Comments on responses by the Applicant to the Examining Authority's First Written Questions

Part B Specific Comments relating to REP2-025

Legend

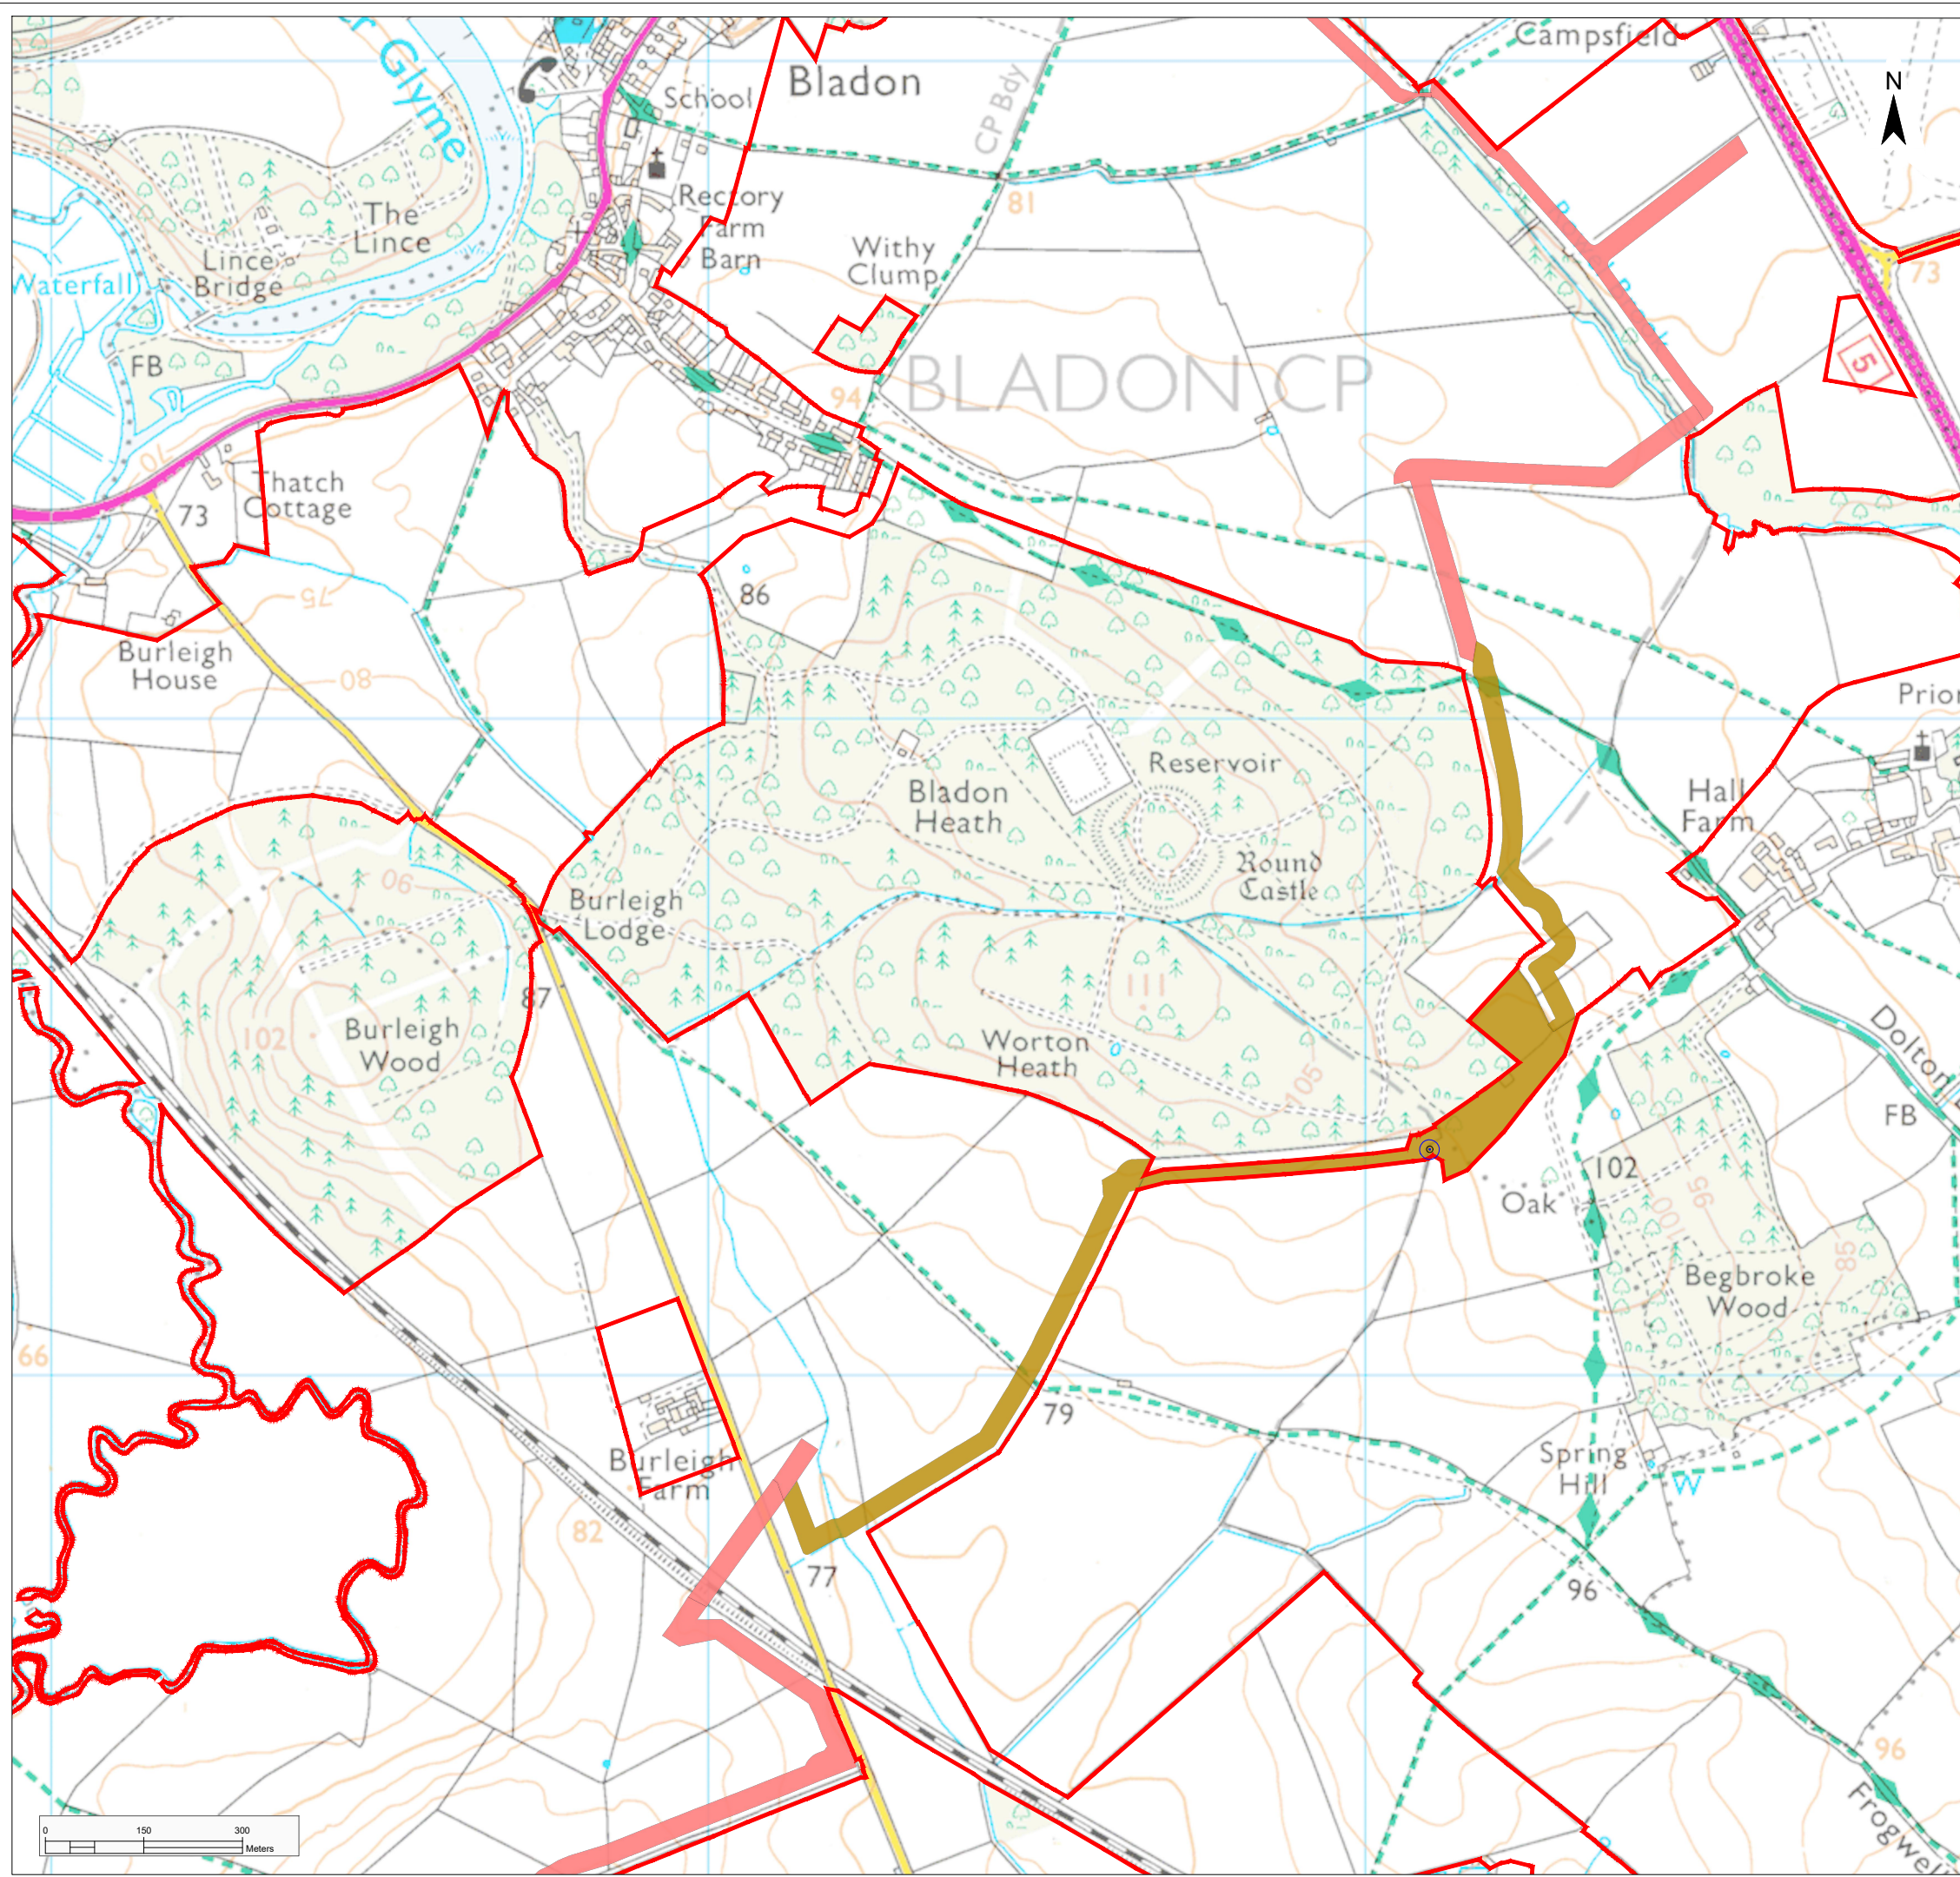
10.2 As for the 'skyline', I referred in paragraph 6 of my Written Representation (REP1-155) to the Applicant's misleading statement about 'keeping off high ground' (APP-034 at page 79). For example, the Illustrative Masterplans clearly show panels along the Purwell Farm ridge. Parts of this ridge are shown on the 3rd and 4th photographs in my 'Nomination for location for an ASI' (REP2-121)

Material related to Q1.14.6 – inadequate selection of viewpoints and photomontages

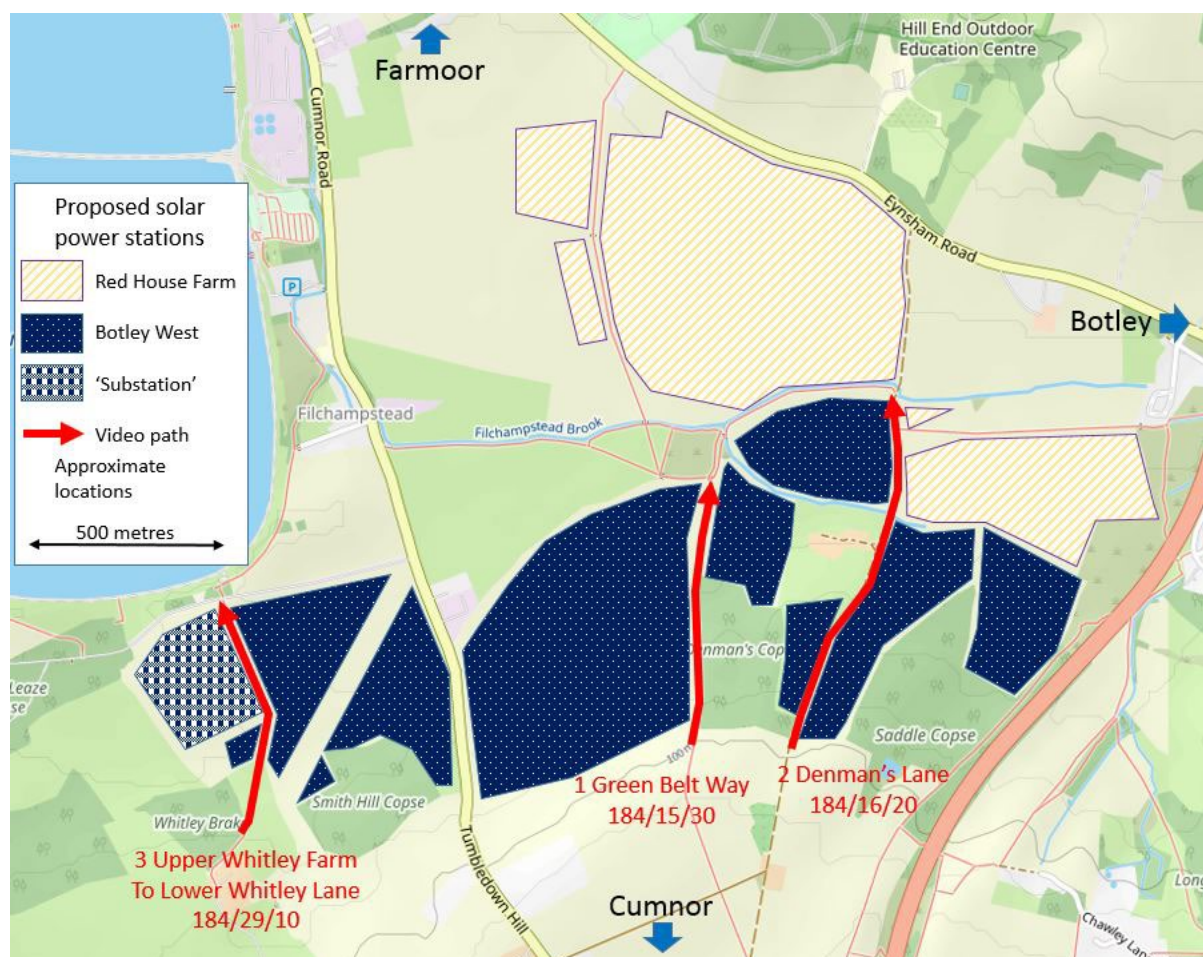
11.2 A difficulty for us all is that despite my and others repeated requests for more viewpoints and photomontages, there are for example still none along Lower Road in the long stretch between viewpoints 22 and 30, and important current viewpoints such as 22, 24, 26, 33 and 39 still have no photomontages. I suspect that the Local Planning Authorities would have asked for more viewpoints if they had anticipated
